Our Case Number: ABP-314724-22

Re: Railway (Metrolink - Estuary to Charlemont via Dublin Airport) Order [2022]
Metrolink. Estuary through Swords, Dublin Airport, Ballymun, Glasnevin and City Centre to Charlemont, Co. Dublin

Re: *Railway (Metrolink–Estuary to Charlemont via Dublin Airport) Order 2022*
Case Reference Number **NA29N.314724**

My name is Emir McDonagh and I live at 34 Dartmouth Square. I am writing with regard to the proposed development of a Terminus for the Metrolink project at Charlemont, Dublin 6, under the Railway Order 2022 (Metrolink – Estuary to Charlemont) Ref No NA29N.314724. I have paid the required fee of €50.

TUNNEL ALIGNMENT
SAINT STEPHEN'S GREEN – CHARLEMONT
RO APPLICATION VS DEEPER VERTICAL ALIGNMENT OPTION

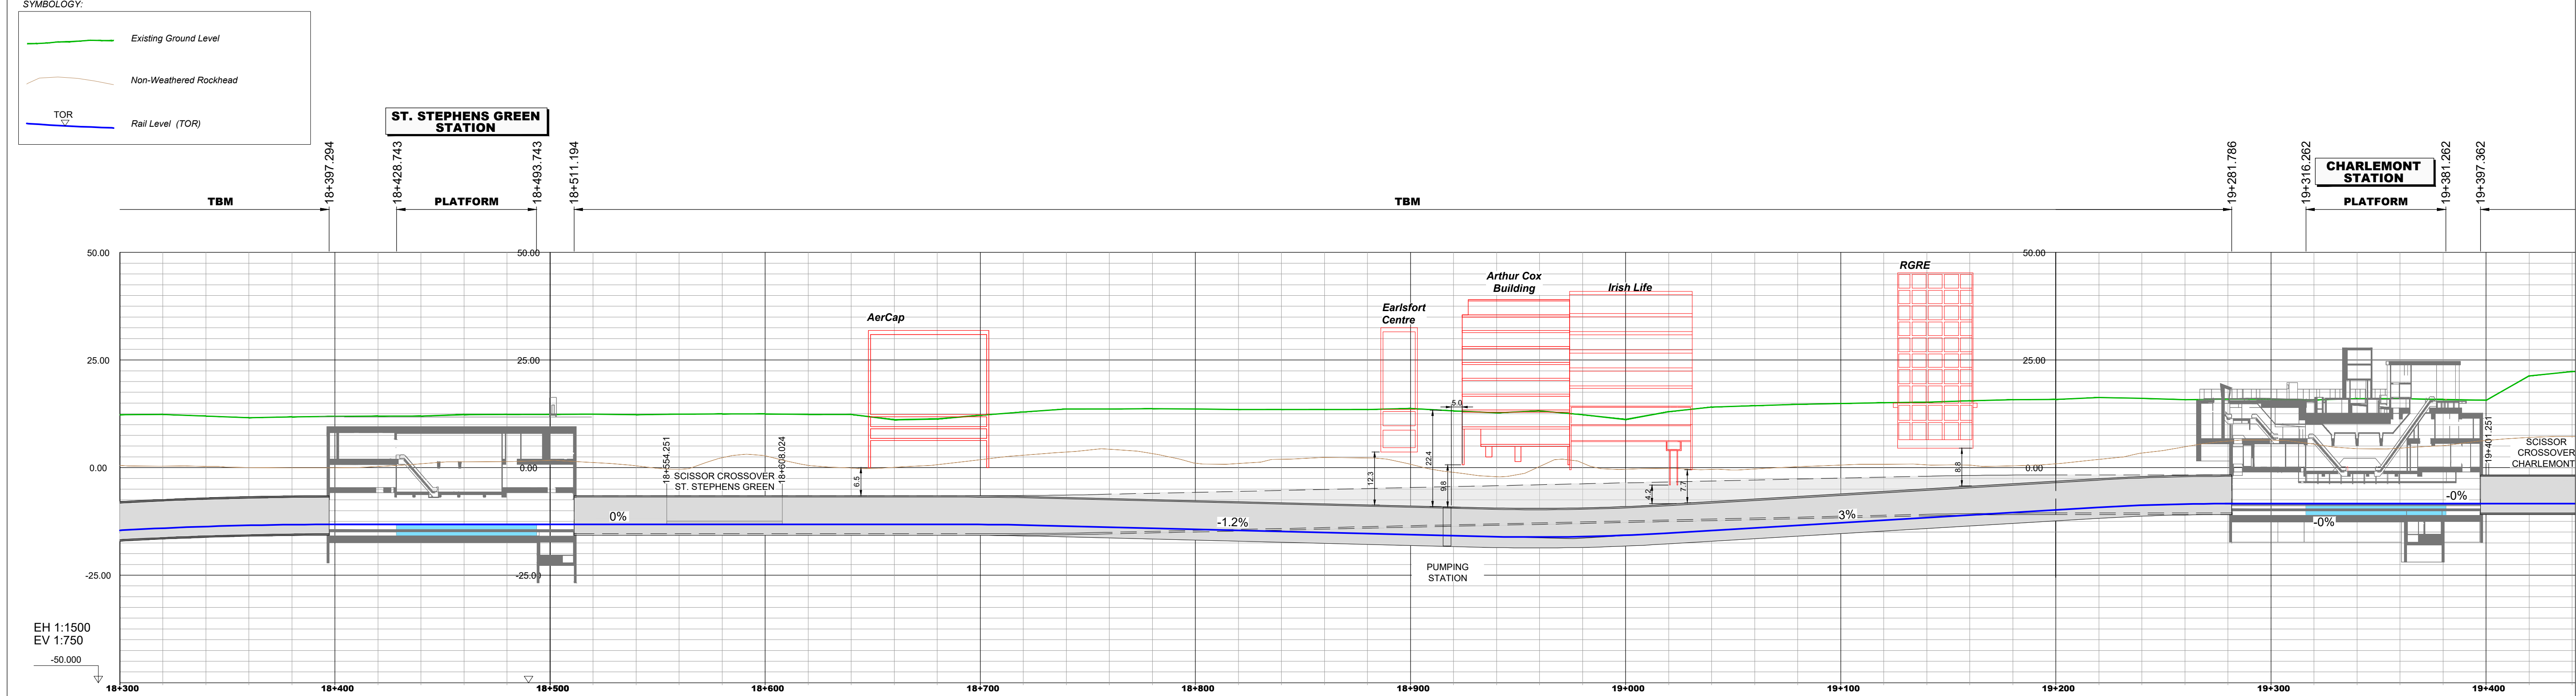
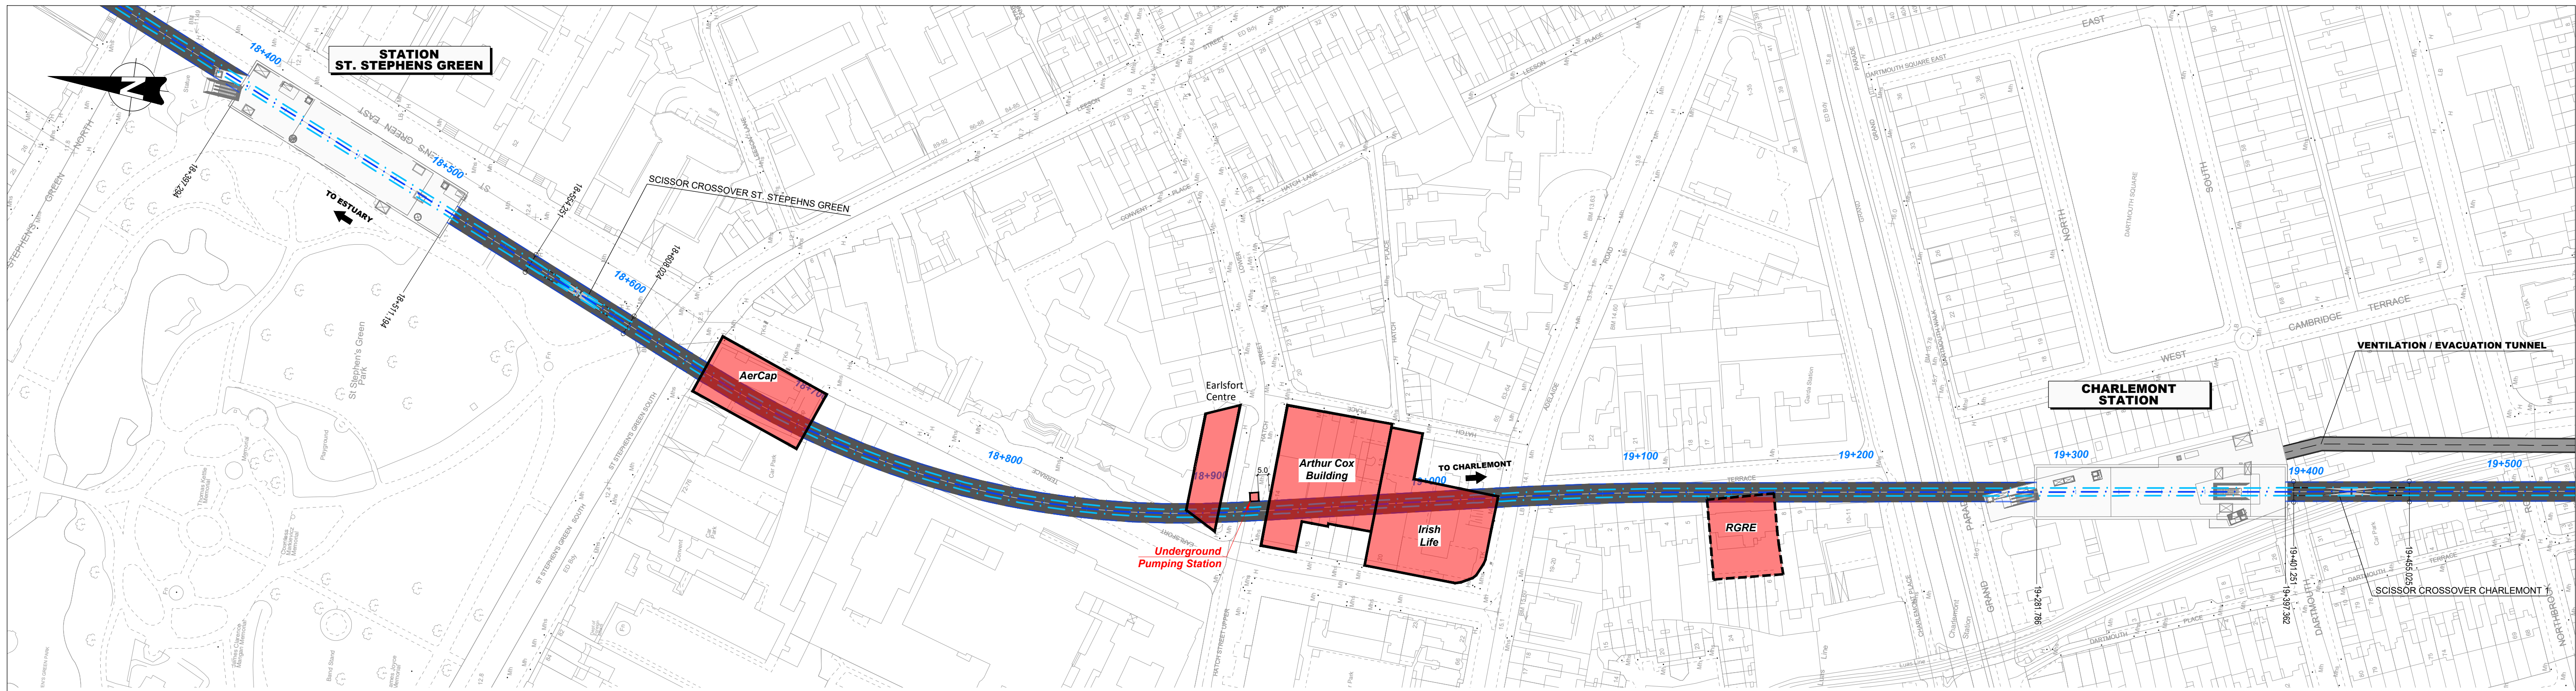
4. **The station box at Charlemont will result in only one possible future tie in** with the Luas Green Line to the south, which would result in an option that was previously dismissed as part of the Tie-In study from March 2017. No alternatives to the station box at Charlemont were considered as it had been fixed through the design of the overhead Hines Grand Parade commercial development. The implications of this new alignment is very significant on our wider community as it will involve top down construction that will only be possible when many houses on Manders Terrace, Oakley Road and Charleston road are demolished.

1. Omit from the Railway Order the section from Tara Street Station to Charlemont Station and associated onward tunnel extension and intervention tunnel
2. Require the submission of a railway order for a section from Tara Street Station to St. Stephens Green which would effectively provide for a terminal hub station that can integrate with the Luas Green Line, multiple bus routes and future DART underground.

Drawing Title
Figure 9.5 St Stephen's Green in Relation to Other Public Transport Facilities
Sheet 14 of 15

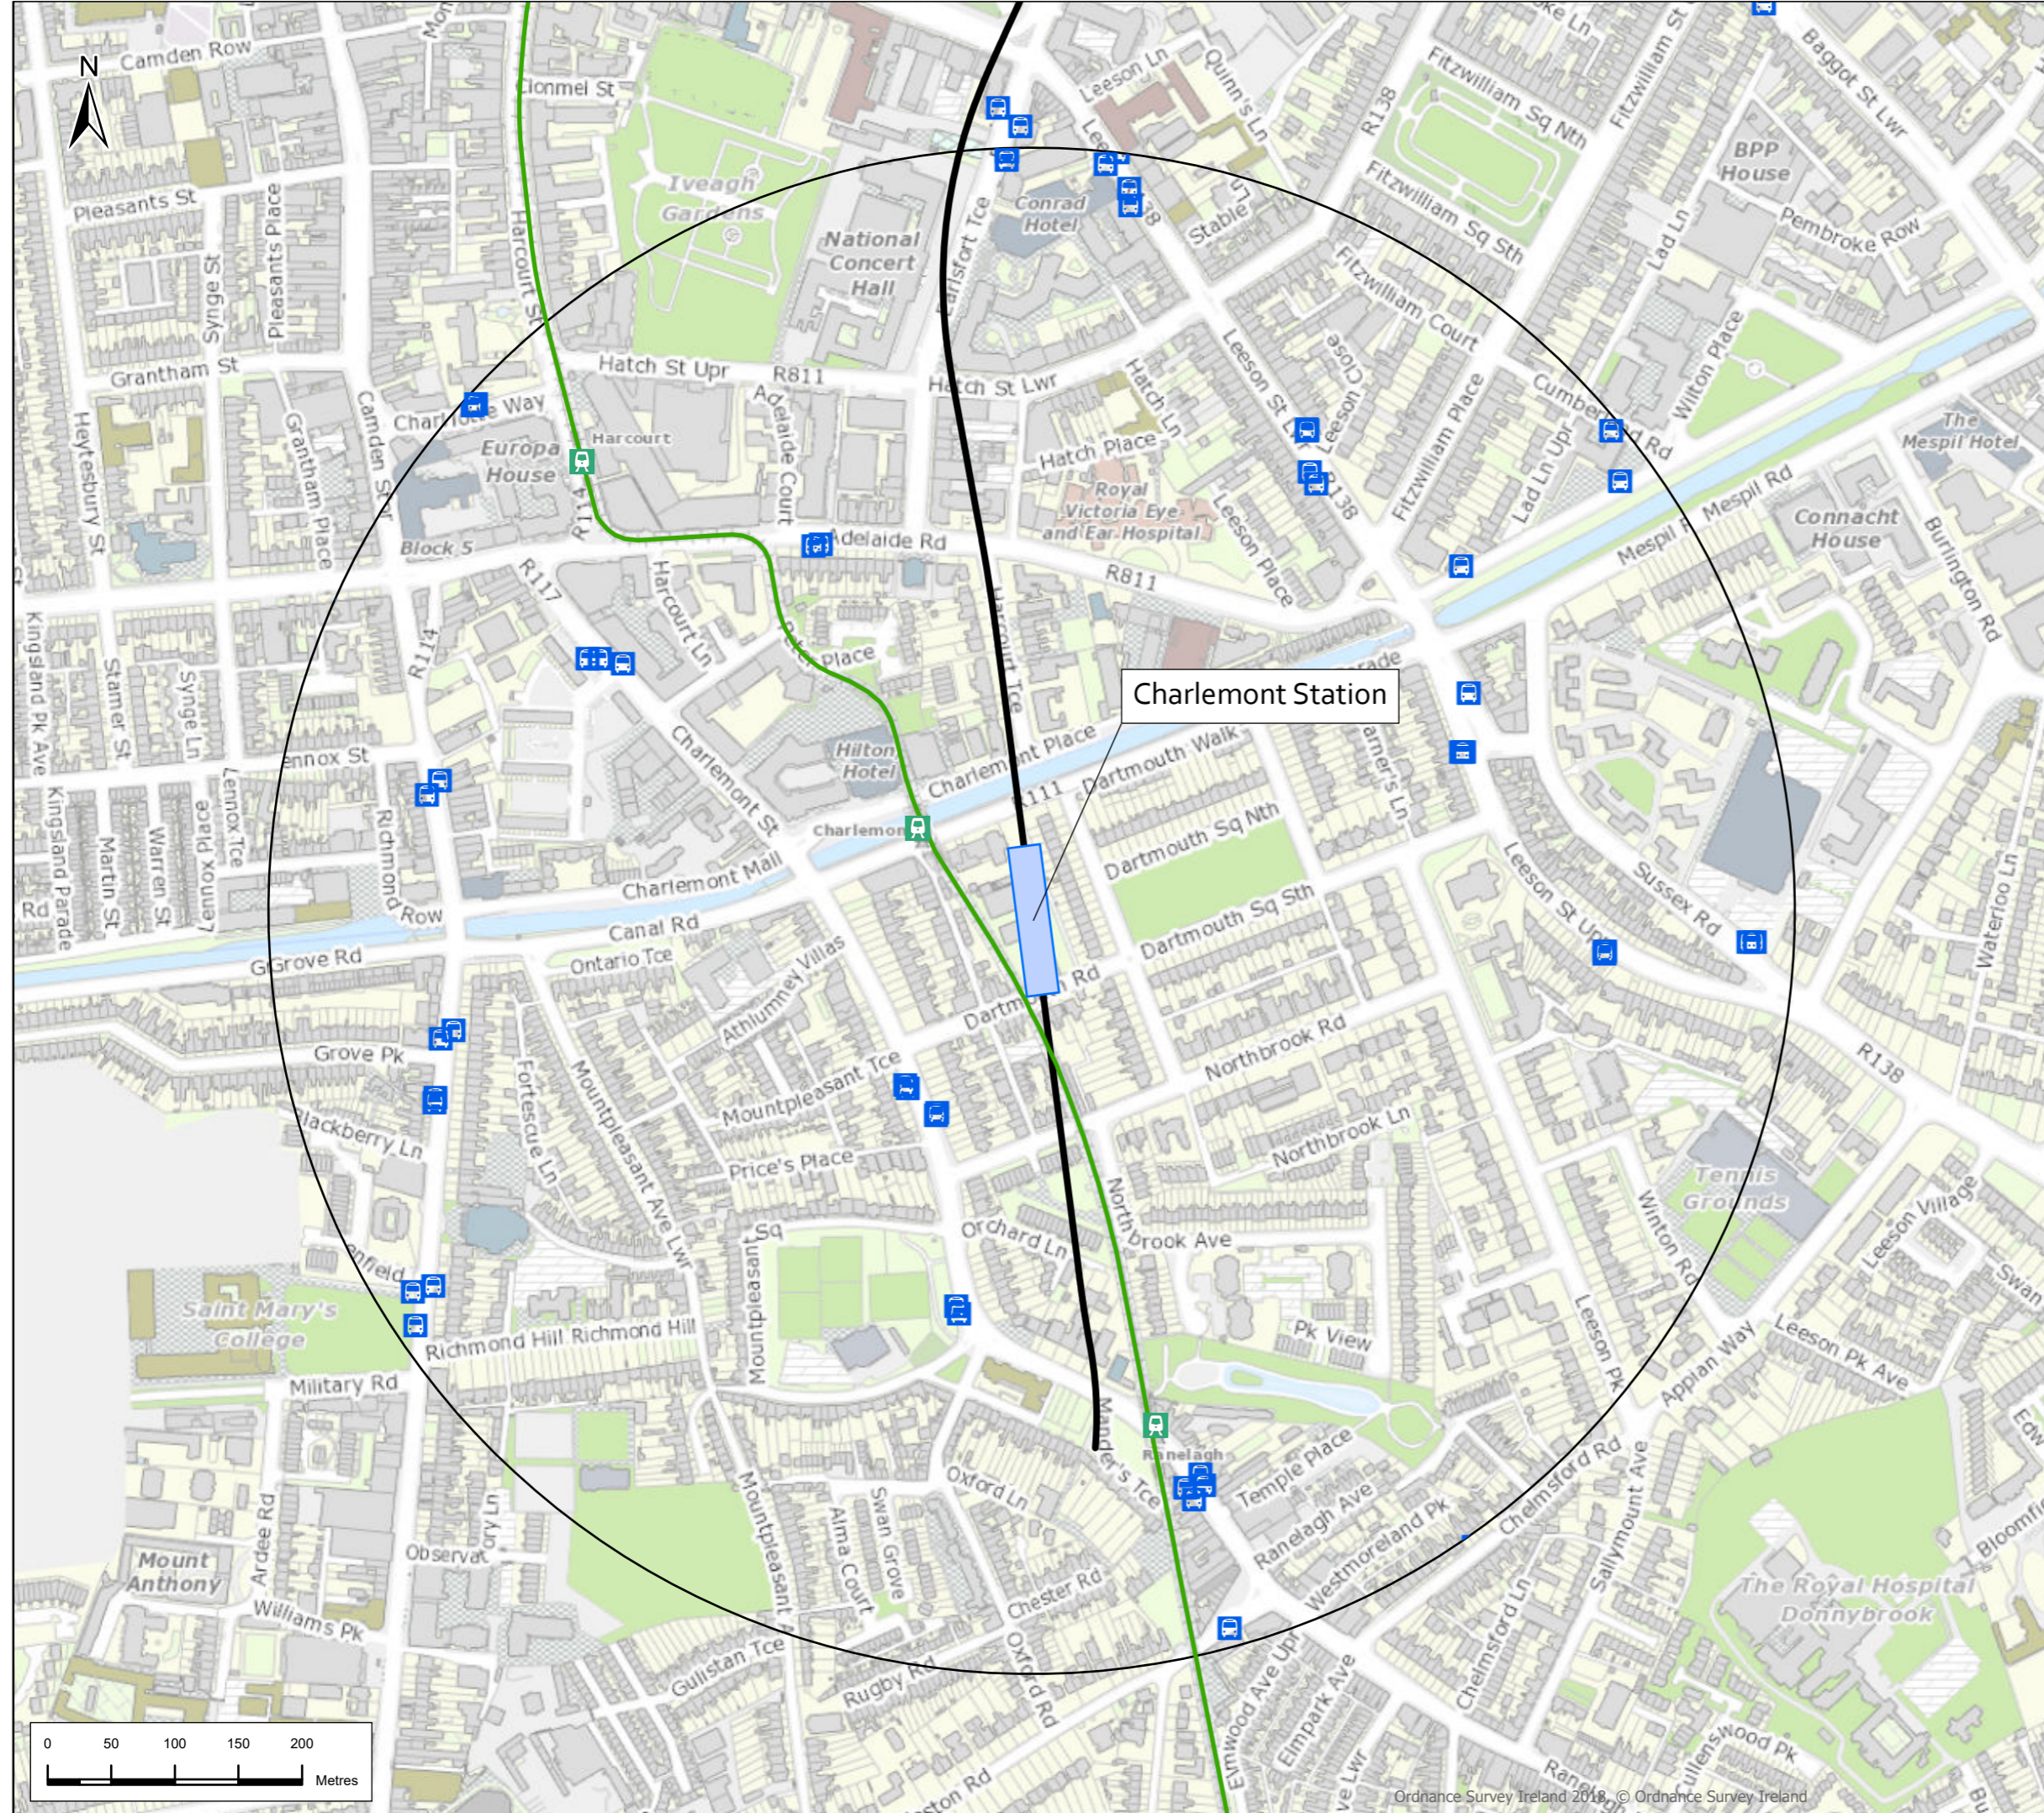
1. **Charlemont is the incorrect strategic location for a Terminus hub and spoke system** as it is too far out along the Luas Green Line spoke and would prejudice future options for integration of networks and services. St. Stephens Green is the most appropriate location as it provides for interchange with bus, Luas and future DART underground. The project incorrectly dismisses St. Stephens Green West as an appropriate terminal station. It only considers St. Stephens Green East and Charlemont. Furthermore, no Study has been completed by NTA/TII as part of the entire Metrolink project on the optimal location for a City centre terminus.
